Report title:	Designers response to Stage 1 Road Safety Audit, Pagham South Local Centre
Date:	14 th February 2022
Document reference and revision:	2152/RSA/DR/02
Prepared by:	Highgate Transportation
On behalf of:	Hanbury Properties

A Stage 1 Road Safety Audit (ref: 211206) was produced by Avon Traffic & Safety Services on 14th February 2022 with regards to the proposed spine road and local centre access at land west of Pagham Road, Pagham, West Sussex. The scope of the survey also included an indicative access to a future school with associated waiting and loading restrictions (double yellow lines and school keep clear markings), the access to the school and associated road markings will be confirmed as part of a forthcoming planning application for the school.

TITLE:
SPINE ROAD AND
LOCAL CENTRE ACCESS

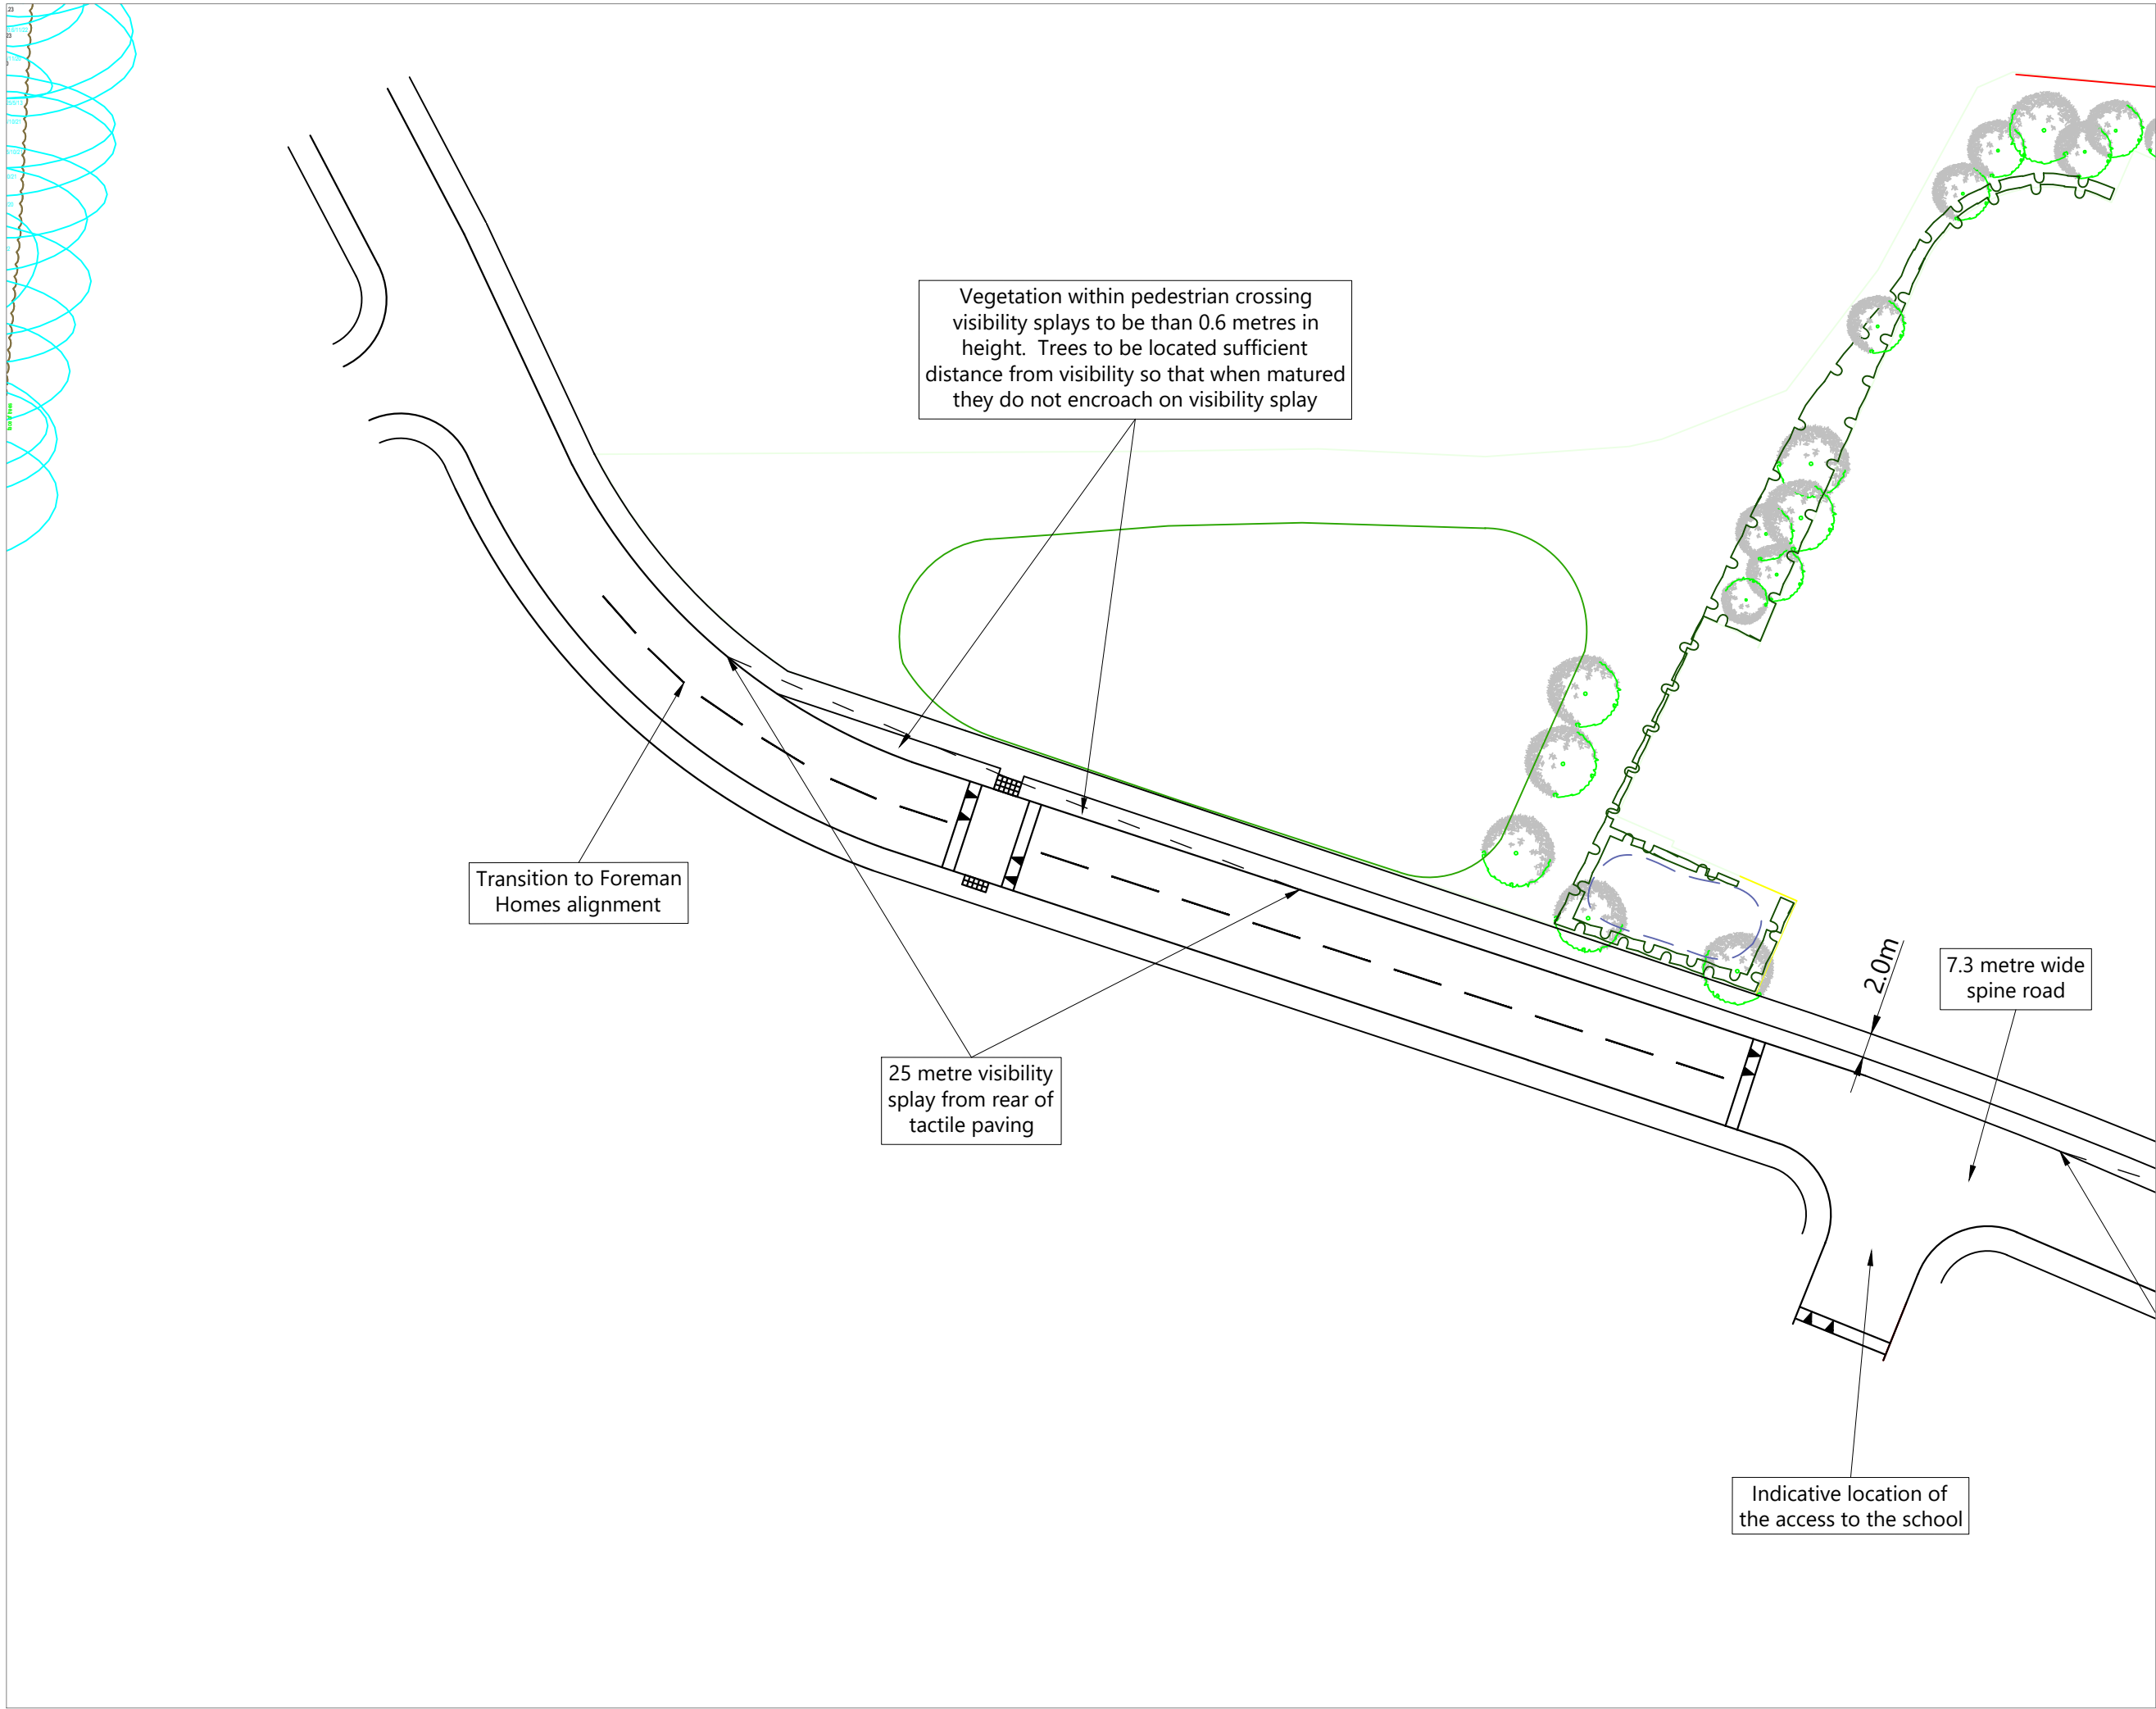
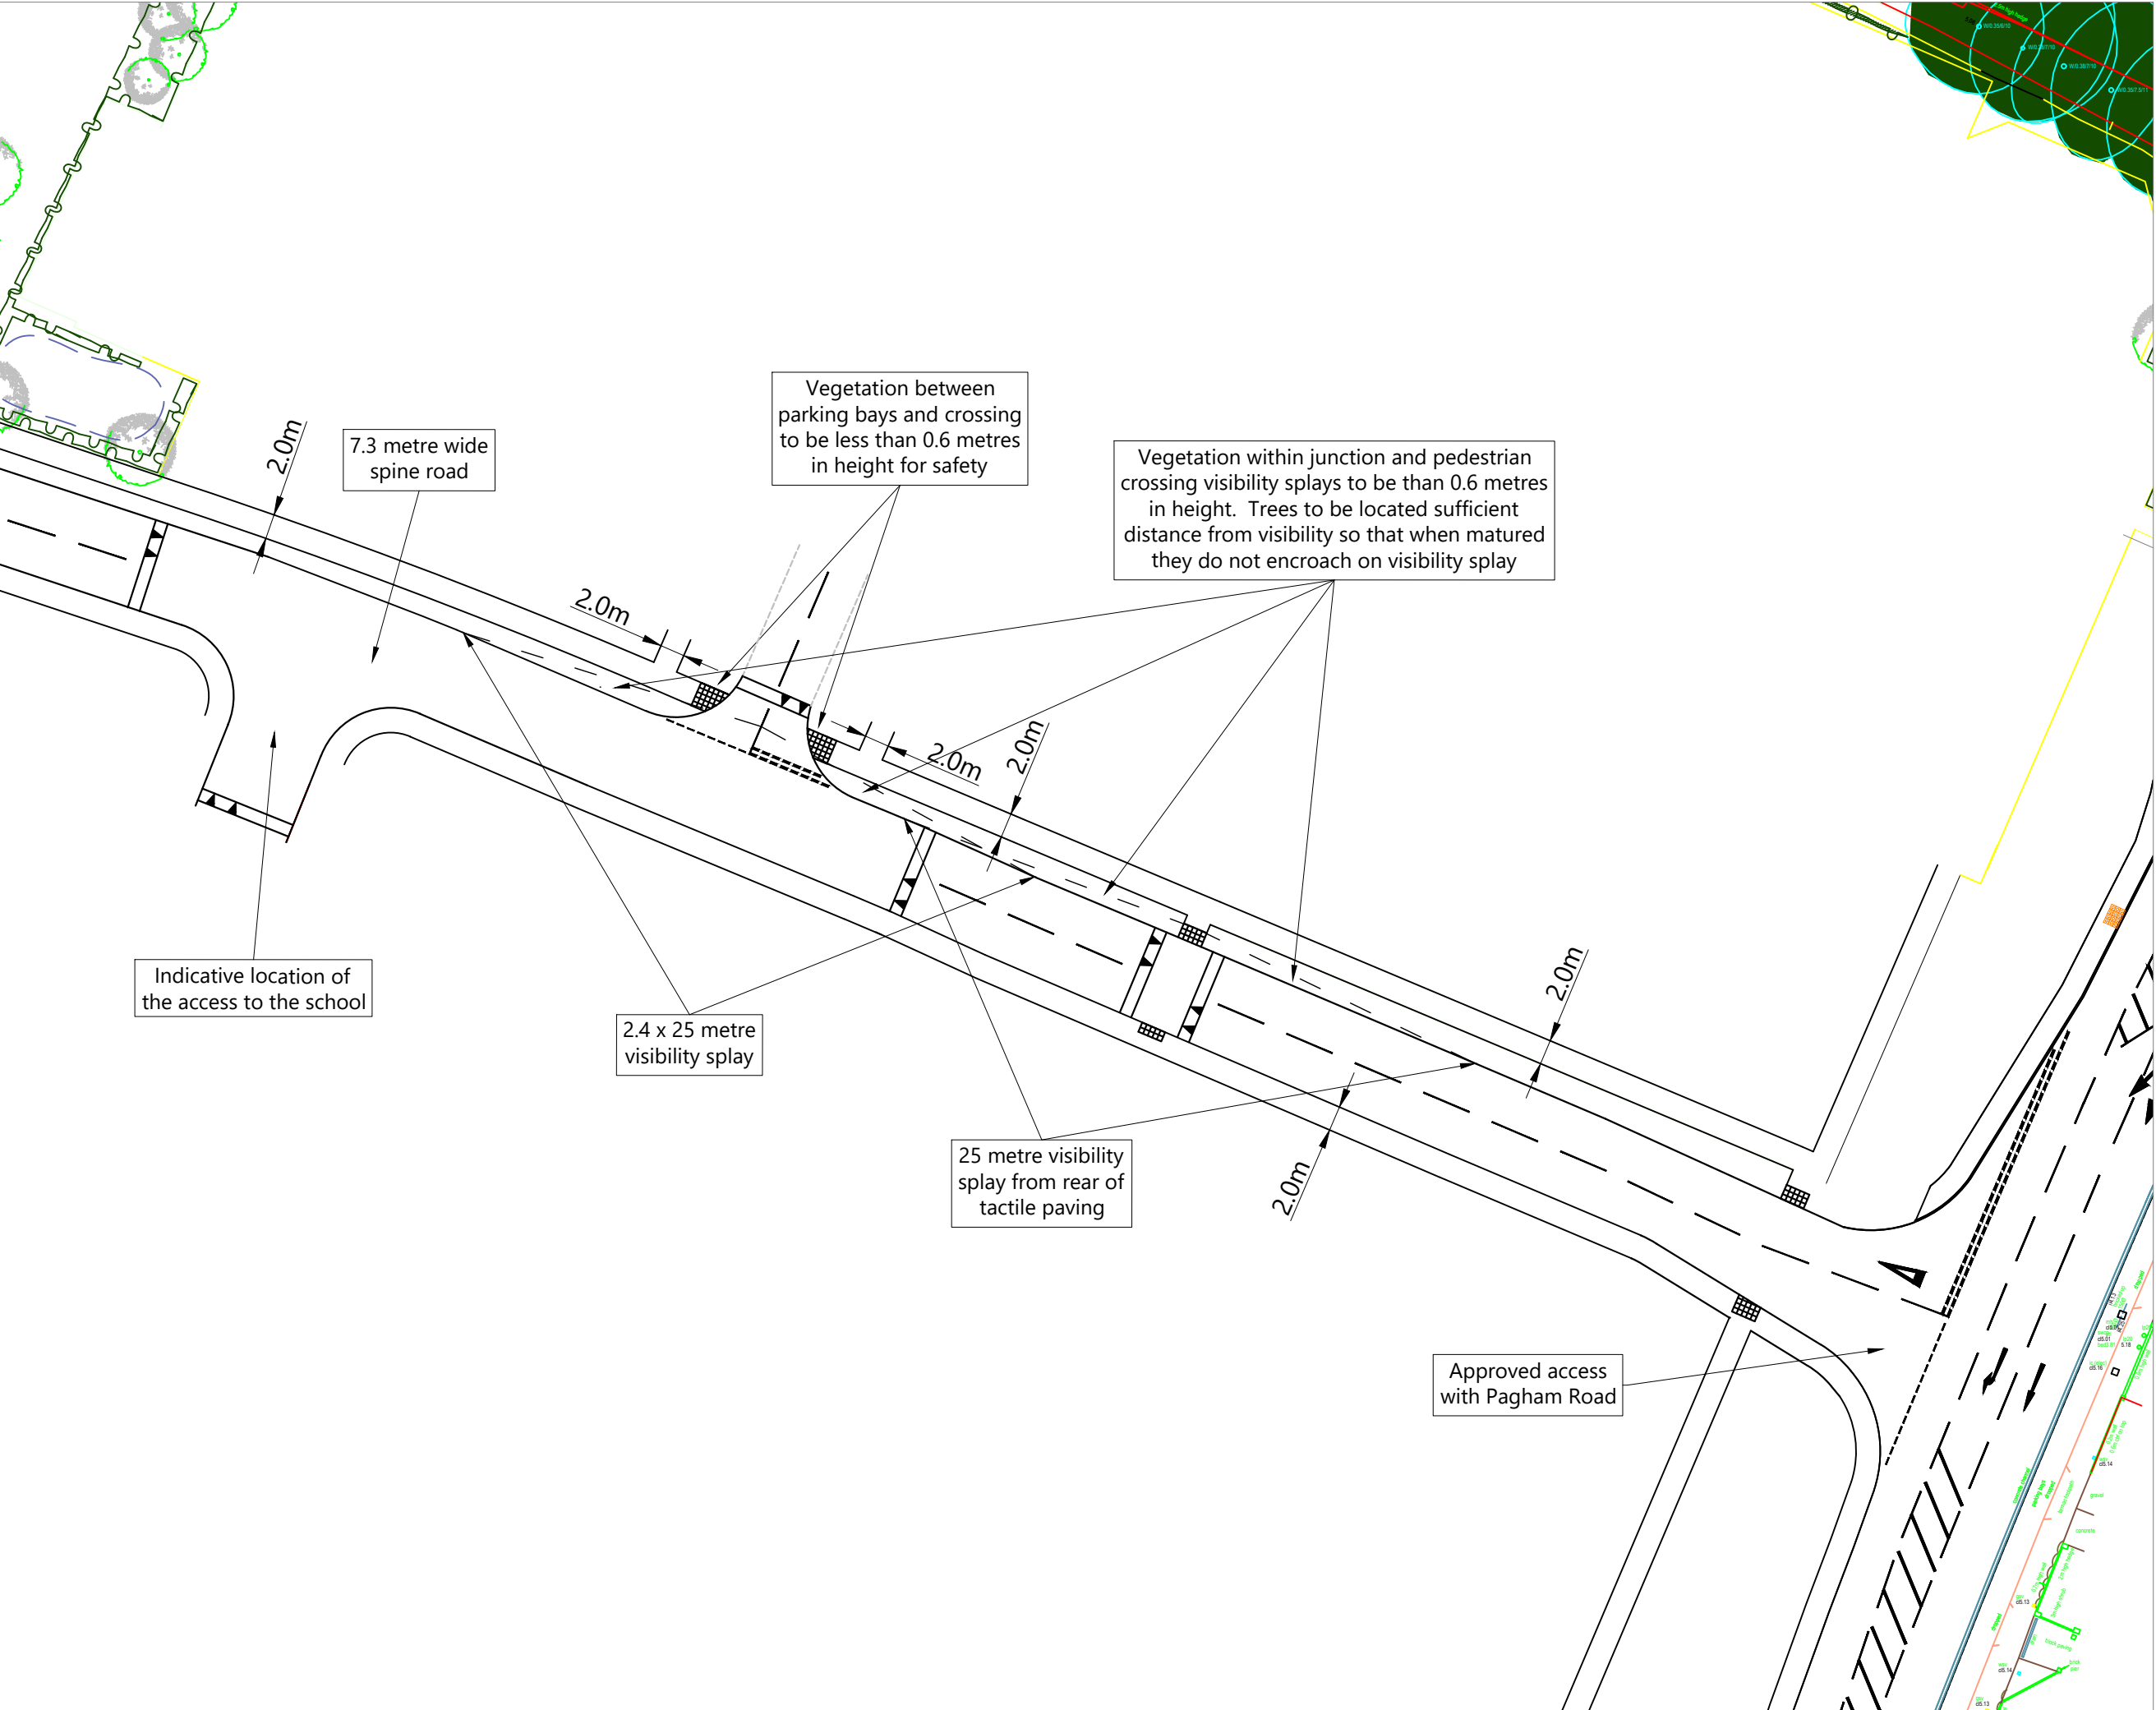
RSA issue	RSA recommendation	Design response	Organisation	Overseeing Organisation response	Agreed RSA action
Speed table at west end of site It is not clear if the spine road will be a bus route, however if it is, the proposed speed table is not bus-friendly, as it is not long enough for a bus to completely mount the table before leaving the far side. The resultant motion could cause injury to bus passengers	If the spine road is to be a bus route, extend the speed table to a minimum length of 6.0 metres	Accepted – It is not yet known if the spine road will form a bus route. However, there are no material downsides in providing the lengthened raised table as suggested and this is now shown on the updated drawings.		It's considered unlikely that the internal road support a regular bus service; this possibility hasn't been identified through the agreed design principles. The designer has nevertheless agreed to the auditors recommendation.. This is acceptable to WSCC.	The speed table referred is to be extended in length to a minimum of 6.0 metres.

RSA problem	RSA recommendation	Design Organisation response	Overseeing Organisation response	Agreed RSA action
School Keep Clear markings, south side of spine road The School Keep Clear markings are shown to the east of the school entrance only, meaning that parents' vehicles will legally be able to stop and wait to pick up/drop off students to the immediate west of the entrance. In this position they could obscure pedestrians crossing south to north, such that they would risk being struck by westbound vehicles	Add School Keep Clear markings to west of the school access	Accepted – School Keep Clear markings have been provided to the west of the indicative school access. It should be noted that the school access shown is indicative and when the school application is brought forward the access will be designed in detail. This will include the extents of road markings to ensure the continued safe operation of the spine road and accesses.	The Designers response is noted and agreed. It's recognised that the school access and associated road markings may be amended at a later time.	No further action required at this stage. The extent of School Keep Clear markings should be reviewed as part of the detailed design.

RSA problem	RSA recommendation	Design Organisation response	Overseeing Organisation response	Agreed RSA action
Spine Road, north side between proposed waiting restrictions and the bend at west end of audit site It is possible that school parking will extend along the north side of the spine road from the end of the proposed restrictions, over the speed table (which is an informal pedestrian crossing point) and around the inside of the bend. Parked vehicles in this area will obstruct the view to the west of pedestrians waiting to cross north to south on the speed table, such that they would risk being struck by eastbound vehicles	Extend the waiting restrictions westward from the proposed end point, to a point adjacent to the next junction around the bend	Accepted – Waiting restrictions have been provided through the northern side of the pedestrian crossing and its visibility splays to the west of the school.	Although the Developer's strategy for managing school related parking is currently unclear, which may in turn affect the extent of waiting restrictions, the Designers response accepted.	No further action is required at this stage. The waiting restrictions should be implemented through the detailed design.

RSA problem	RSA recommendation	Design Organisation response	Overseeing Organisation response	Agreed RSA action
Speed table at west end of site It is possible that school parking will extend along the south side of the spine road from the end of the proposed restrictions, over the speed table (which is an informal pedestrian crossing point). If this occurs, pedestrians crossing south to north on the speed table will be obscured by parked vehicles, such that they would risk being struck by westbound vehicles	Provide a short length of waiting restrictions on the south side of the spine road, to protect the speed table/crossing point	Accepted – Waiting restrictions have been provided through the southern side of the pedestrian crossing and its visibility splays to the west of the school.	The Designers response is noted and agreed.	No further action is required at this stage. The waiting restrictions should be implemented through the detailed design.

RSA problem	RSA recommendation	Design Organisation response	Overseeing Organisation response	Agreed RSA action
School Keep Clear markings SKC restrictions only relate to the carriageway on which they are marked, and so their restriction does not extend to the back of footway in the same way that double yellow lines do. With a smaller upstand of the speed table than a conventional kerb, there is a danger that drivers will park on the footway adjacent to the speed table and parking enforcement would then not be able to take place if vehicles are clear of the SKC. This could cause conflict issues for pedestrians. Furthermore, parking in these areas would only be	Continue the double yellow lines through the School Keep Clear markings	Partially Accepted – Waiting restrictions have been provided alongside school keep clear markings through the raised table to restrict obstructive parking on the verge and/or footway. It is however not accepted that planning enforcement would be unable to take action if parking occurred outside of the hours of operation as they would be covered by Rule 243 of the Highway Code <i>"DO NOT stop or park ...opposite or within 10 metres (32 feet) of a junction, except in an authorised parking space"</i>	The Designers response regarding the extension of the waiting restrictions is noted and agreed. WSCC however point out that the rule within the Highway Code is not legally enforceable, but more good practice. Unless there are enforceable restrictions vehicles could park within 10 metres of a junction. The exception to this is only where a parked vehicle is causing an obstruction, which can be dealt with under Section 99 of the Road Traffic Regulation Act 1984.	No further action is required at this stage. The waiting restrictions should be implemented through the detailed design.
